STRUCTURAL APPRAISAL AND REPORT ON
DETACHED BARN 1 AT BROOKSIDE FARM, MAIN ROAD,
PONTESFORD, SHREWSBURY SY5 0UA

Job Number: 21/120
Date: 20th October 2021

Drawing  
**Existing First Floor Plans**

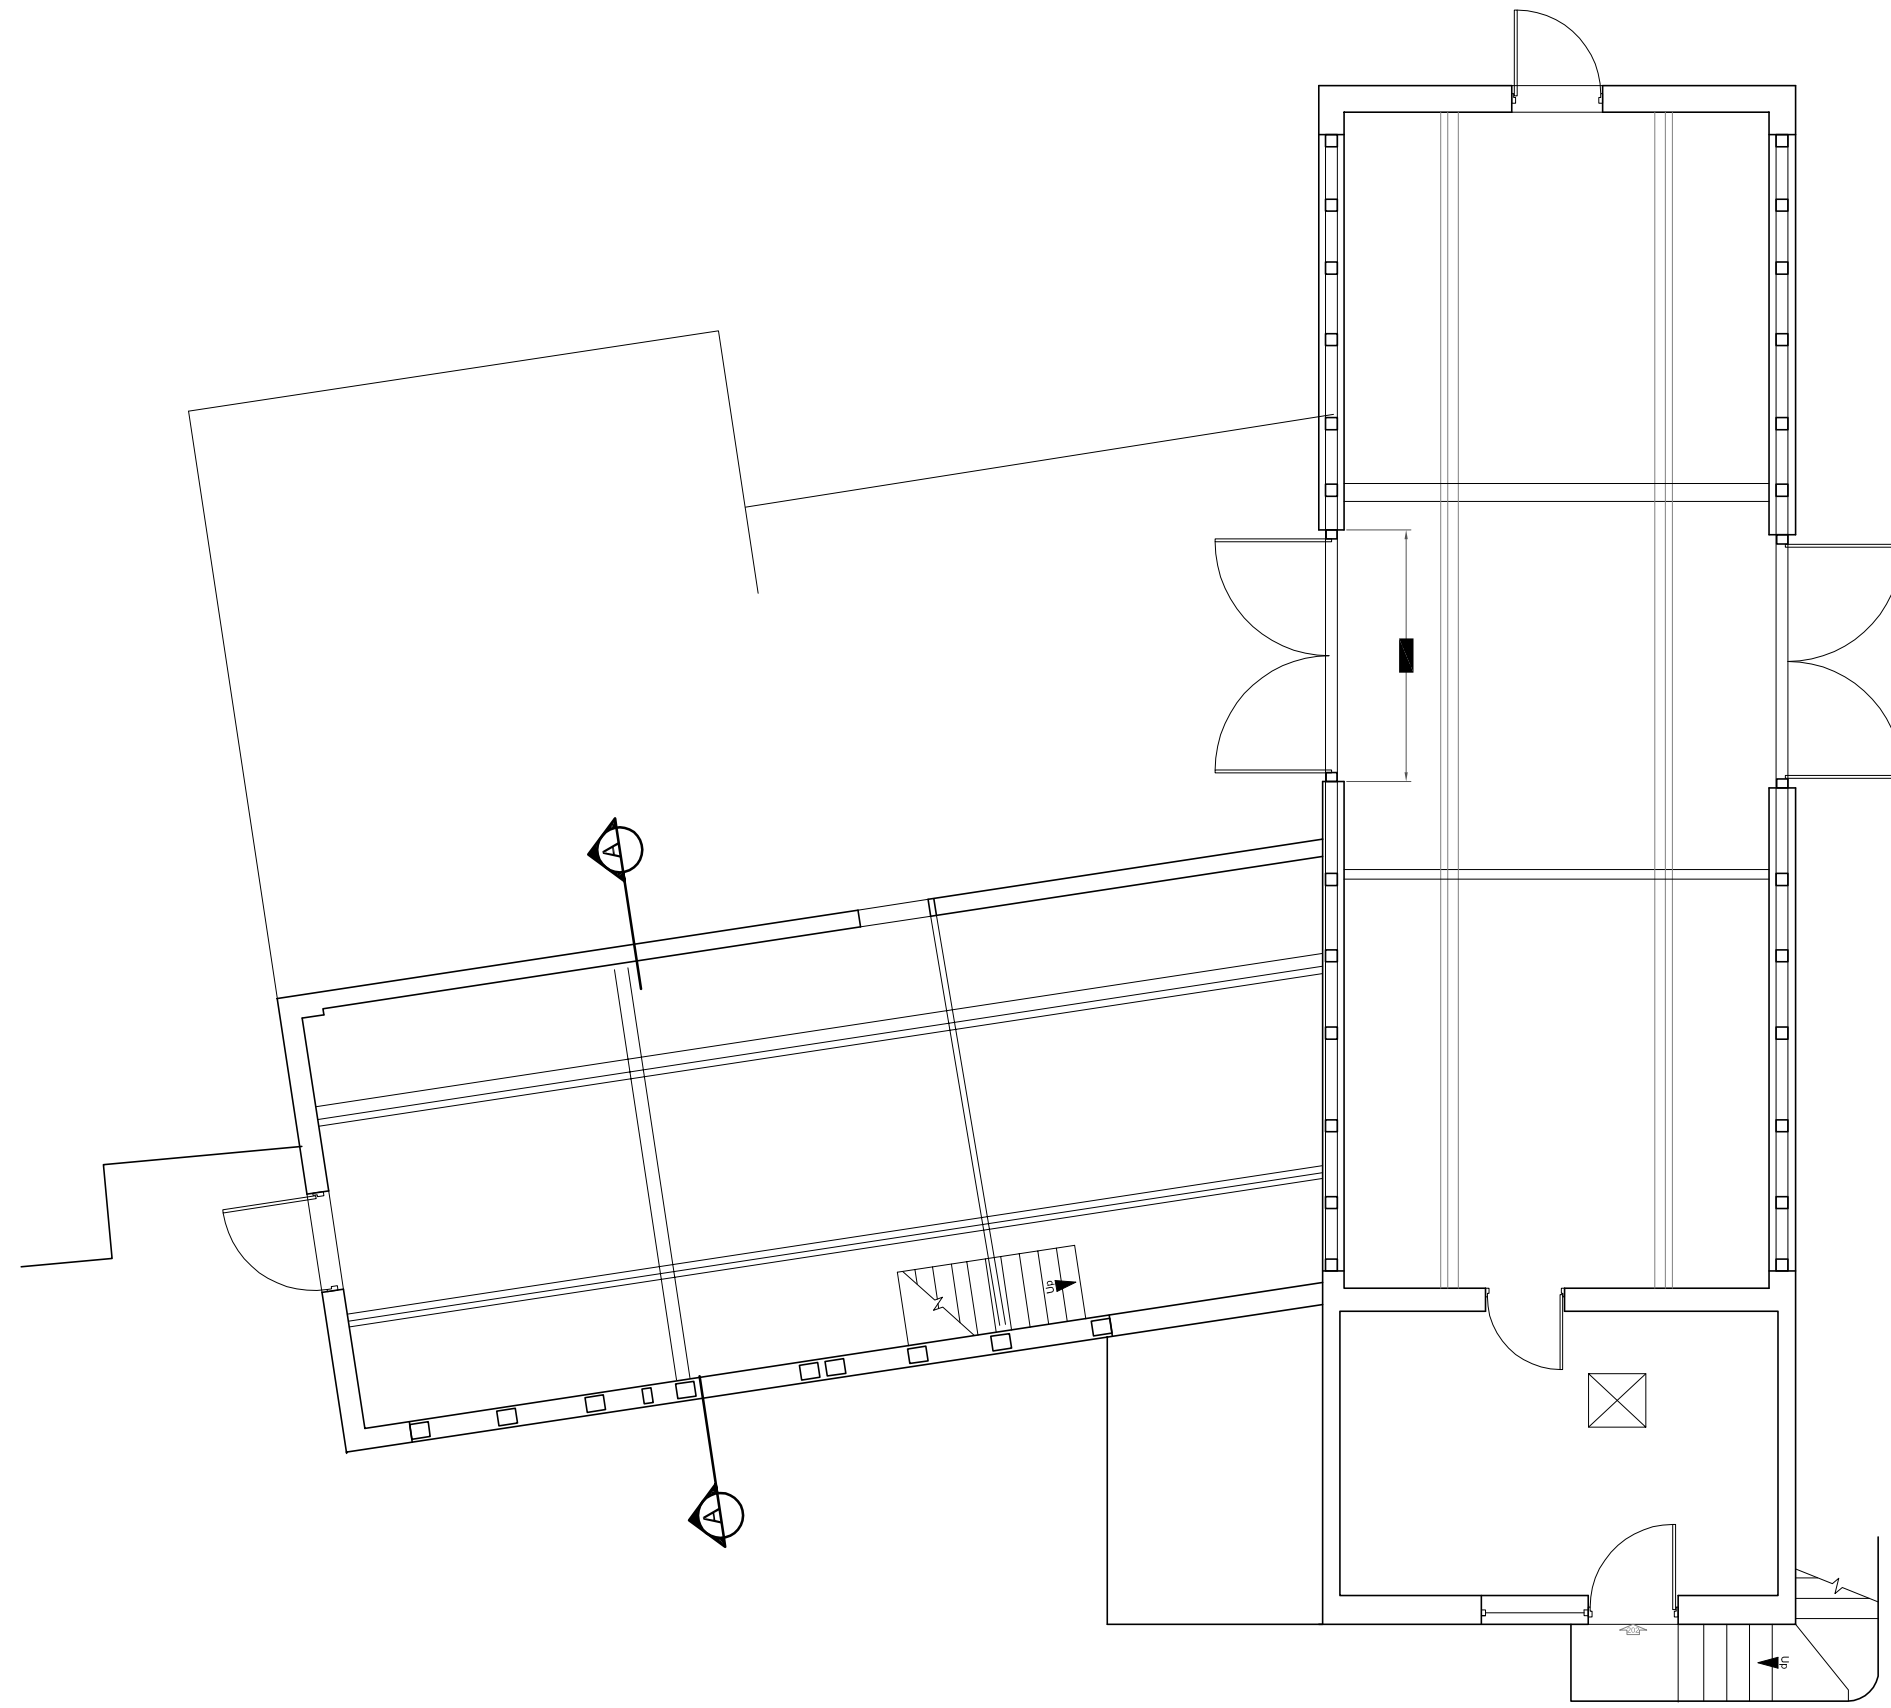
The first floor deck was not accessed for safety reasons, but was particularly low to the ground and will not be suitable for re-use.

A tie bar was present to the North Western end, at wallplate level.

Access was not gained as the deck comprised tree sections and noted as dangerous.

Purlins appeared to be in reasonable condition, but will require checking/strengthening, as appropriate.

Walls were timber framed above brickwork/first floor level and there was evidence of distortion and roof spread, which although not excessive will require addressing during the works. Rebuilding/replacement of framing is likely to be required.

- 6.1 Allow for strengthening existing purlin sections, or introducing new members, to ensure that vertical loads are adequately supported and that the aspect of lateral spread is addressed and controlled to within acceptable limits for habitable accommodation.
- 6.2 Provide new first floor decks, as required. Should existing members be retained, they will need to be design checked for suitability. Similarly, where floor beams are exposed, they should be checked for charring, in accordance with the Building Regulations and British Standards.
- 6.3 Strap roof and first floor to external walls.
- 6.4 Carefully take down distorted areas of masonry and rebuild using materials to match existing.
- 6.5 Carefully cut out damaged or fractured masonry and replace/repair as necessary, using materials to match existing.
- 6.6 Strap internal/external wall junctions.

Drawing
Existing Ground Floor Plans

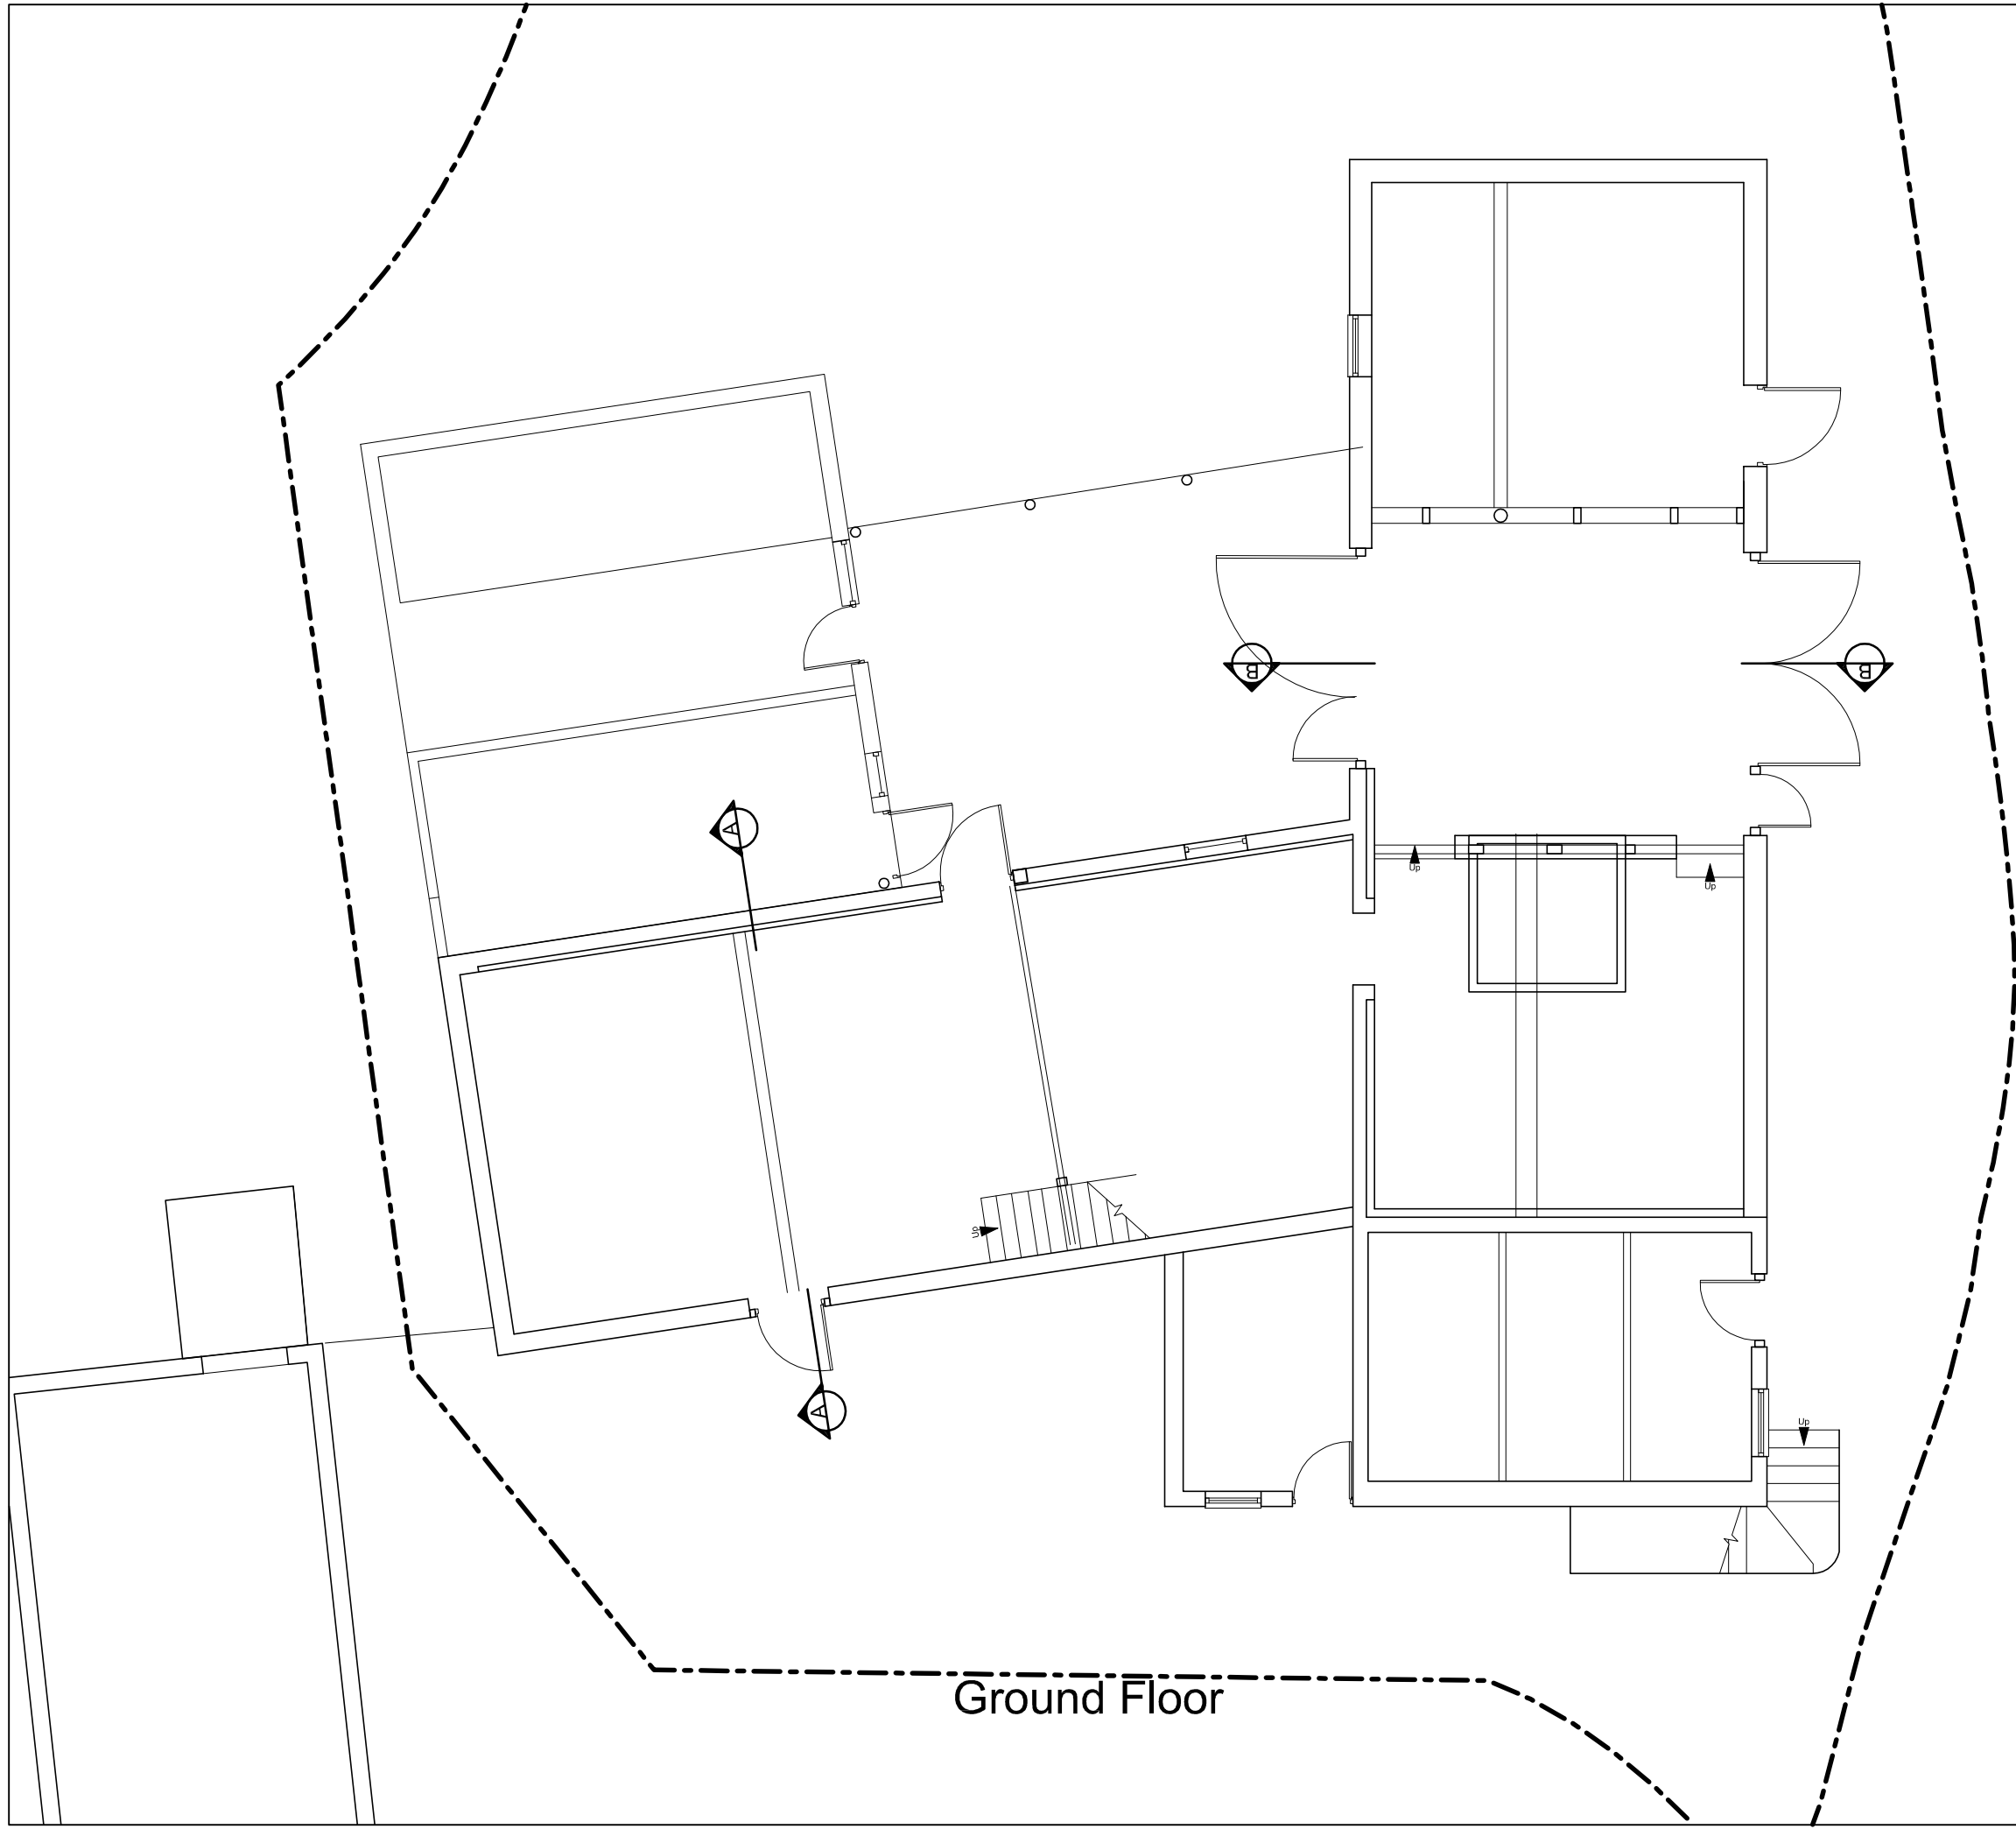
The triangular section of brick wall above the dairy roof line leaned outwards.

A straight joint in brickwork was visible above the right hand edge of the dairy door opening and it appeared that the arched opening had been partially infilled to accommodate the current door and window arrangement.

The roof covering to the tool shed/store was slate and there were undulations to the roof line, with a dip towards the eaves, indicating deflection of the supporting structure.

The timber lintel over the tool shed window opening sloped.

The main elevation to the Barn was clad with metal sheeting above first floor level, with brickwork below. Whilst the brickwork was seen to be in relatively good condition, it leaned outwards below the sheeting line, likely to be due to roof spread and associated movement of the upper framing. This will need to be considered further.

The lower section of wall to Cow Barn 3 bulged outwards significantly adjacent to the South Eastern gable and localised rebuilding will be required.

Brickwork to Cow Barn 4 gable apex was fractured above the hatch doors, indicating lack of adequate lintel support and this section will need to be carefully taken down and rebuilt.

A tie bar was present to the South Western end, at wallplate level, coinciding with the area of distorted brickwork by the dairy, as noted in 4.1.1. This localised area of wall will require rebuilding during the works.

The front wall above the brickwork line was timber framed and displaying signs of movement and distortion, probably due to roof spread. Rebuilding/replacement of framing is likely to be required.

The first floor deck above was supported on two timber beams, which although appeared sound were displaying longitudinal splits.

The front wall brickwork leaned outwards, as noted in 4.1.2 and floor slabs were concrete. Inspection was limited due to the volume of stored materials.

Adjacent to the South Western personnel door opening to Cow Barn 3, a trial pit had been excavated on my prior recommendation, to expose the existing foundation detail and nature of near-surface soils.

The pit revealed that the wall extended down with no spread, to approximately 400mm below external ground level, bearing in to stiff yellow/grey/brown clay.

- 6.7 Install suitably designed lintels over structural openings. Timber lintels to the external wall face will not be acceptable and should be removed. Designed steel beams will be required where it is proposed to remove walls.
- 6.8 Excavate further trial pits to establish foundation details and depths throughout and carry out remedial works as deemed appropriate. Should depths and conditions permit, it may be feasible to provide a thickened edge to a new concrete floor slab, connected to existing walls using drilled and resin grouted dowels, thus providing a monolithic slab/wall diaphragm.
- Alternatively, if levels/conditions do not permit this, underpinning will be required.
- 6.9 Provide new ground floor slab and damp proofing.
